Pagham Beach (Holdings) Ltd

18th October 2021

re. Application Ref: P/143/21/PL - 25 West Front Road, Pagham PO21 4SY
Demolition of existing dwelling and erection of replacement dwelling and detached garage/boat store

Proposed Ground Floor Plan

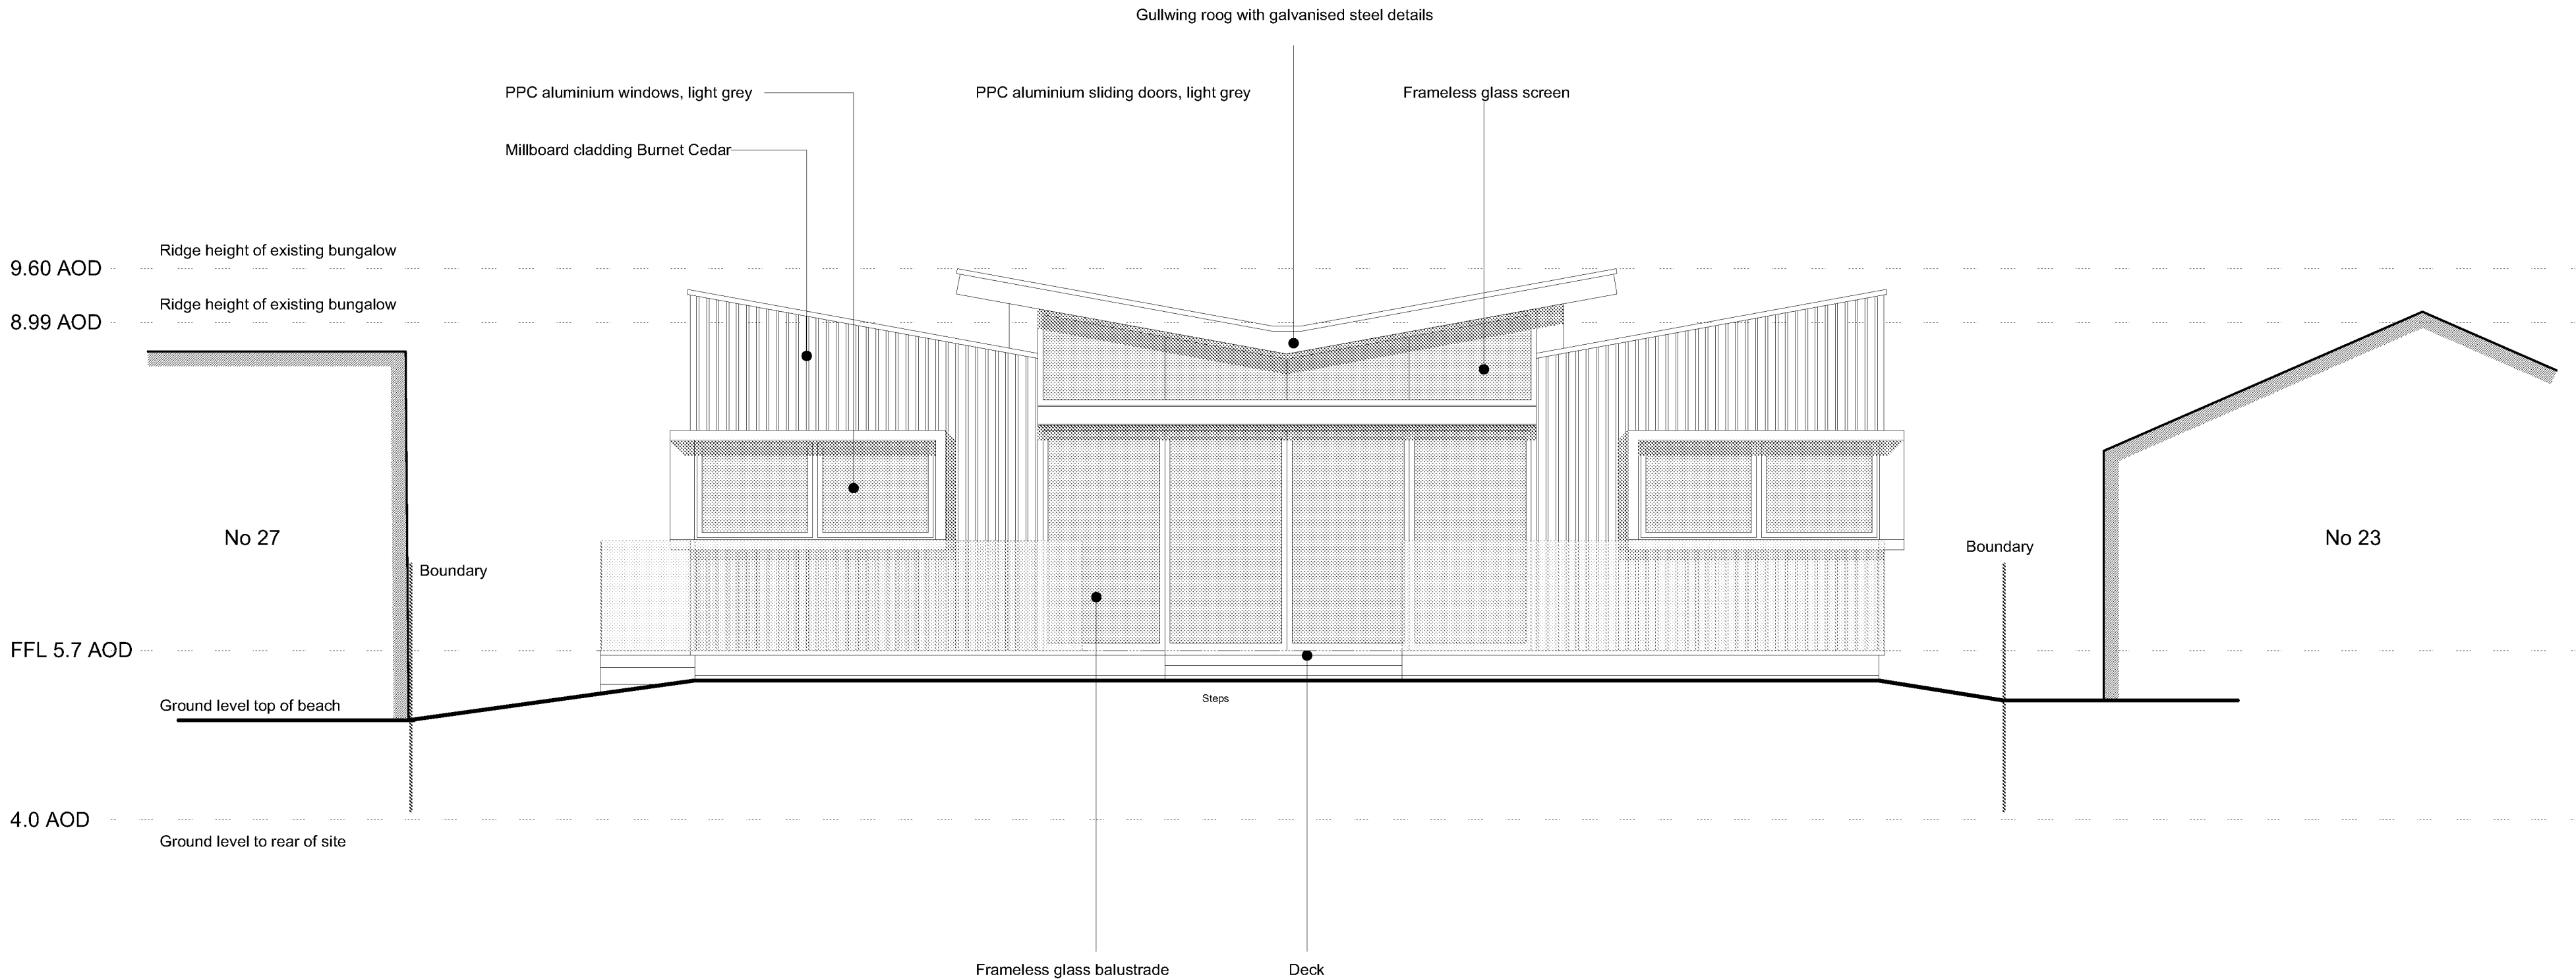
Within the Design & Access Statement the method of heating for the proposed building is to be provided by air-source heat pumps although the position of these appliances are not defined on the Drawings and the Planning Authority may wish to seek further information concerning their positioning and proximity to adjoining dwellings to ensure that no noise disturbance is created.
